Extension to conservatory, first floor side extension, external staircase, balcony area on first floor, alteration of windows on rear first floor & balcony doors & new window on ground floor side elevation.

Anchors Cast 2 Fosters Close Rustington

Thank you for your internet representation made on 19th March 2019 which has been recorded as '**an objection**' with the comments as follows:

Proposal Plans 11

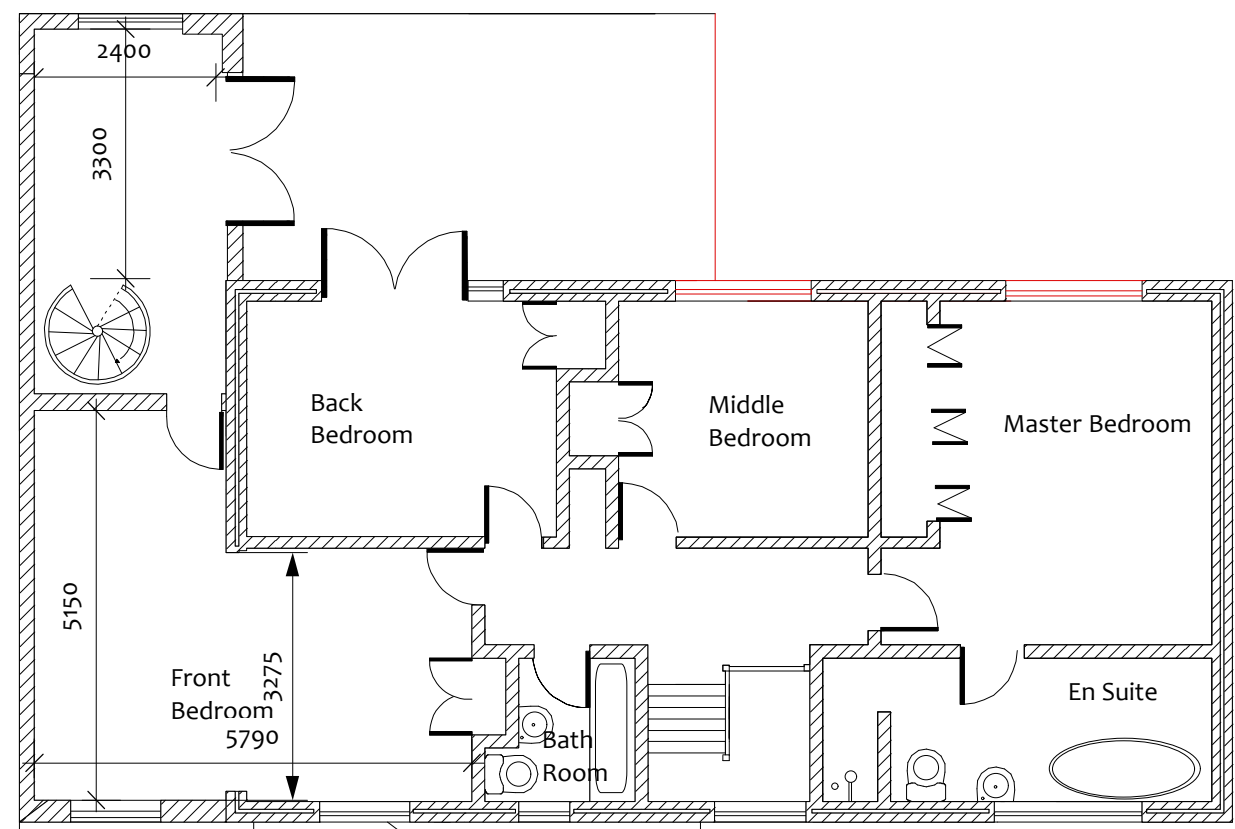
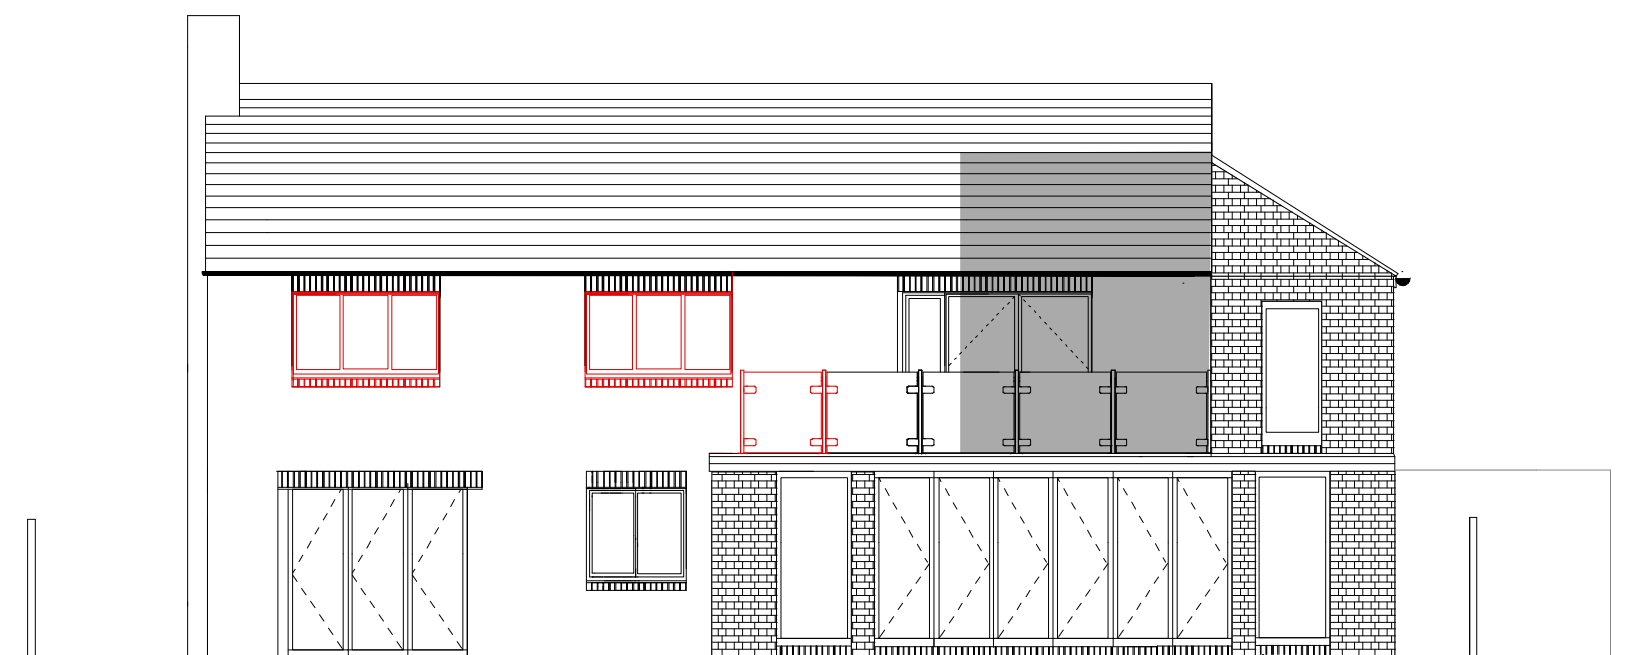
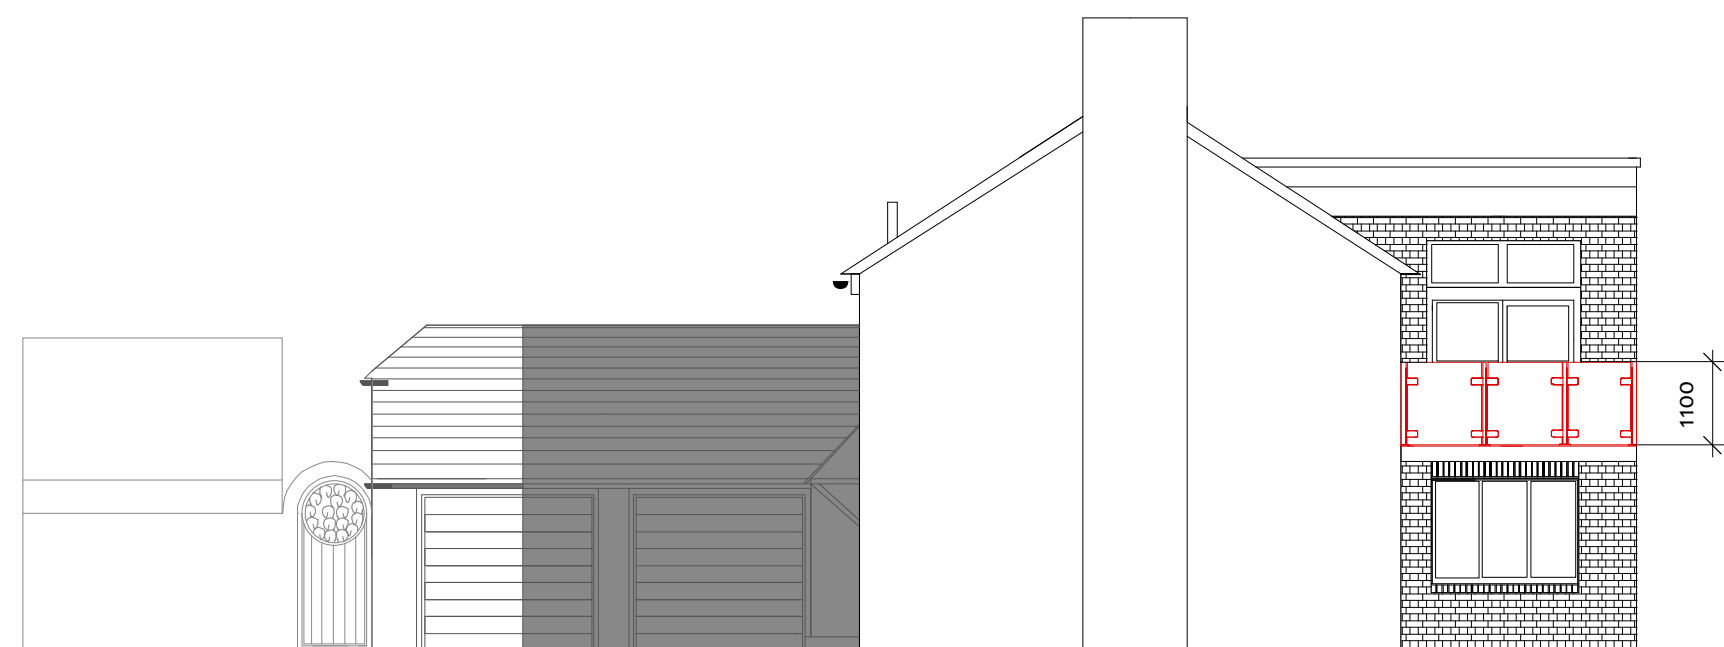
Following review of the plans including the proposed, revised plan submitted and being called Drawing Plans 11 (which we note has still not been submitted to Arun District Council) by Fosters Management Ltd they have consulted with the leaseholders of Fosters flats and we can now advise that their position is as follows:

- 1. Fosters Management Ltd object to the extension past the existing southern boundary line on the east side to form the new reading snug. This extension impacts on sight lines from Fosters. Therefore the plans should be amended to ensure the existing southern boundary line of the property is not extended on. There is no objection however to the balcony being installed extending to the east elevation of the building instead provided there is a low screen at the east end of it.*

- 2. There is currently proposed to be a new window installed at the east end of the northern elevation. Fosters Management have requested that consideration must be given to angling this new window to the west, away from Fosters to avoid any privacy issues with Fosters flats.*

- 3. Finally, Fosters Management Ltd would like to request that consideration is given to applying a light colour render to the existing red brick east elevation wall to match in with Fosters flats.*
